Principal Areas of Disagreement Summary Statement (PADSS) from National Highways		Version Number: 1 Submitted at: 23 June 2023	
Principal Issue in Question	Concern held	What needs to change/be amended/be included in order to satisfactorily address the concern	Likelihood of concern being addressed during Examination
Protective Provisions not agreed, include land and maintenance funding issues and ongoing NH costs	NH not confident it is adequately protected from safety and commercial perspectives	Protective Provisions must be agreed and included in the DCO, including land access, commuted lump sum and funding of NH costs.	Medium
The Transport Assessment has been produced with reference to DfT Circular 02/2013.	The Circular was updated in November 2022 and significant changes were made to how scheme developers must treat the SRN.	A review of the proposals and their assessment must be undertaken against the updated Circular 01/2022	High

Figure 4 - An extract from the interventions's drawing M1J10-NB-A-01

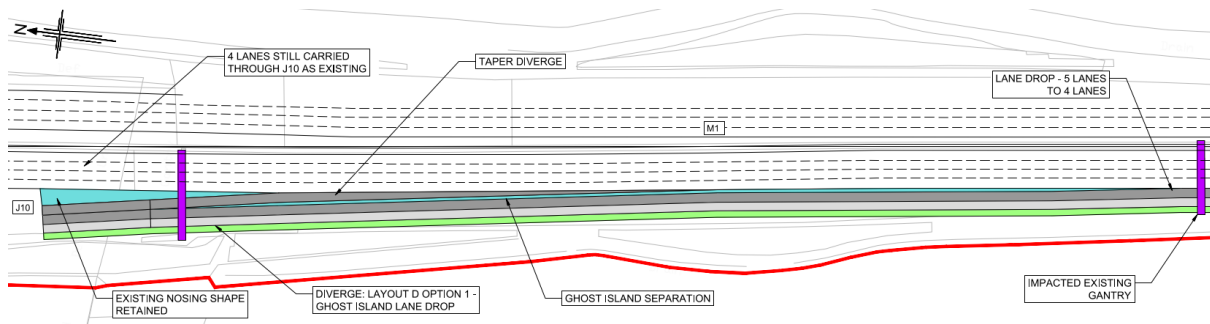
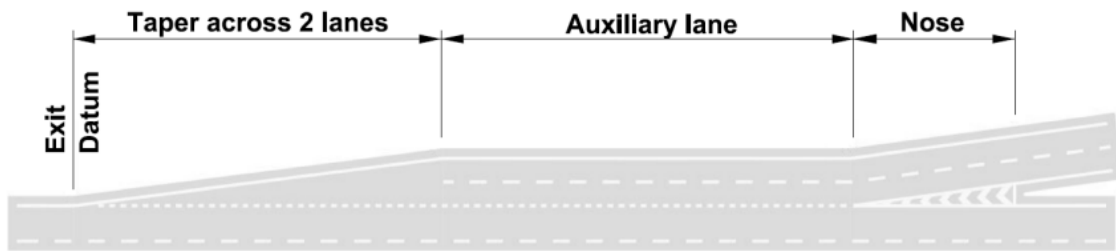
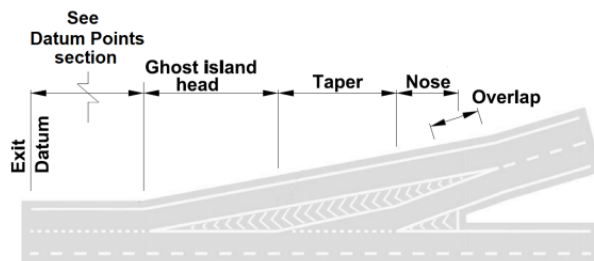
<p>Safety and congestion concern on M1 Junction 10 Southbound on-slip merge and Northbound off-slip diverge</p>	<p>Residual safety and congestion issues at the merge/diverge on the south facing slips and adverse impacts on the M1 mainline.</p>	<p>Design for M1 Junction 10 to be modified to incorporate improvements to the south-facing slip roads and incorporated into the DCO.</p>	<p>Low-medium</p>
<p>Operational impact at M1 Junctions 9, 11 and 11a are not fully understood</p>	<p>In the absence of All Lane Running (or similar), more traffic will use M1 Junction 9 as an alternative to Junction 10, which may lead to congestion and safety issues. Through traffic may also divert onto the A5 via Junction 9 and either Junction 11 or 11a.</p>	<p>Vissim modelling undertaken on Junction 9, with no ALR in place to understand the impact, with mitigations agreed and included in the DCO if required. Saturn modelling to understand the scale of diversion onto the A5 and VISSIM modelling/mitigation if necessary.</p>	<p>Low – medium</p>

Figure 9 – Luton Rising Proposed Upgrade to M1 junction10

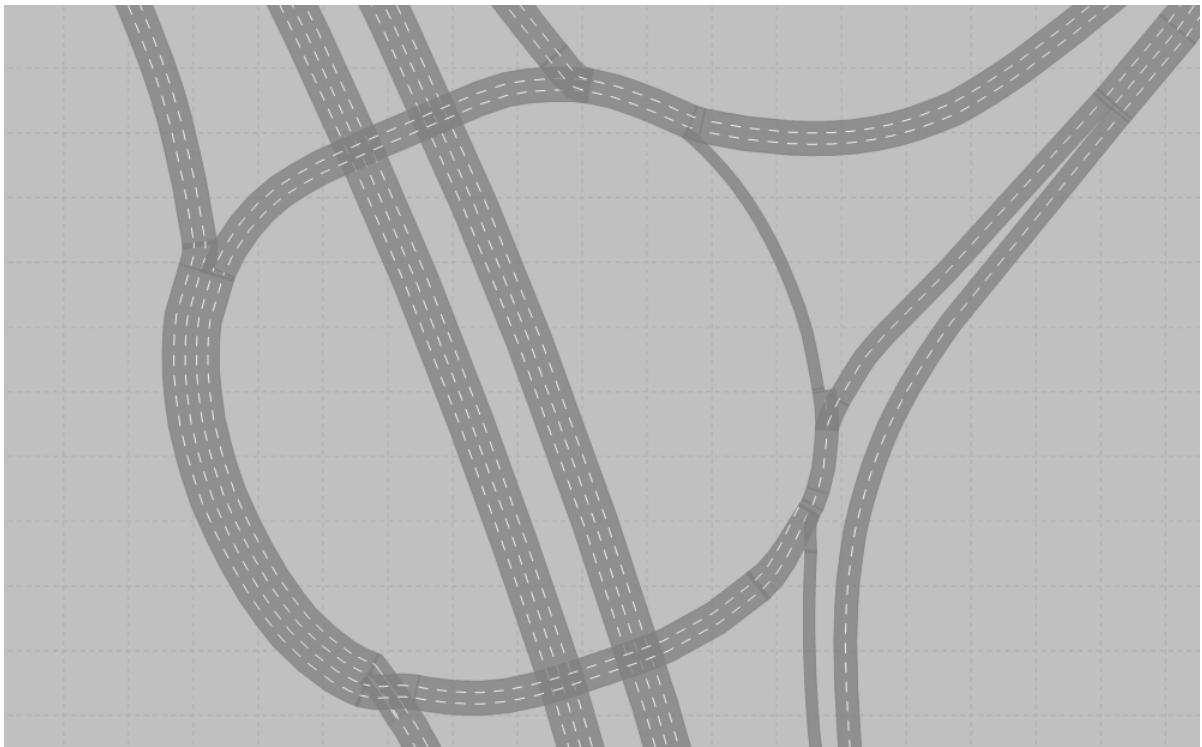
Effective operation of circulatory carriageway at M1 Junction 10, with five lanes on the western side	There will not be a balanced utilisation of lanes on the western side of the circulatory and that there will be resultant weaving, congestion / safety issues.	Design for M1 Junction 10 to incorporate sufficient signing, including gantries and agreed in the DCO in principle.	Medium-high
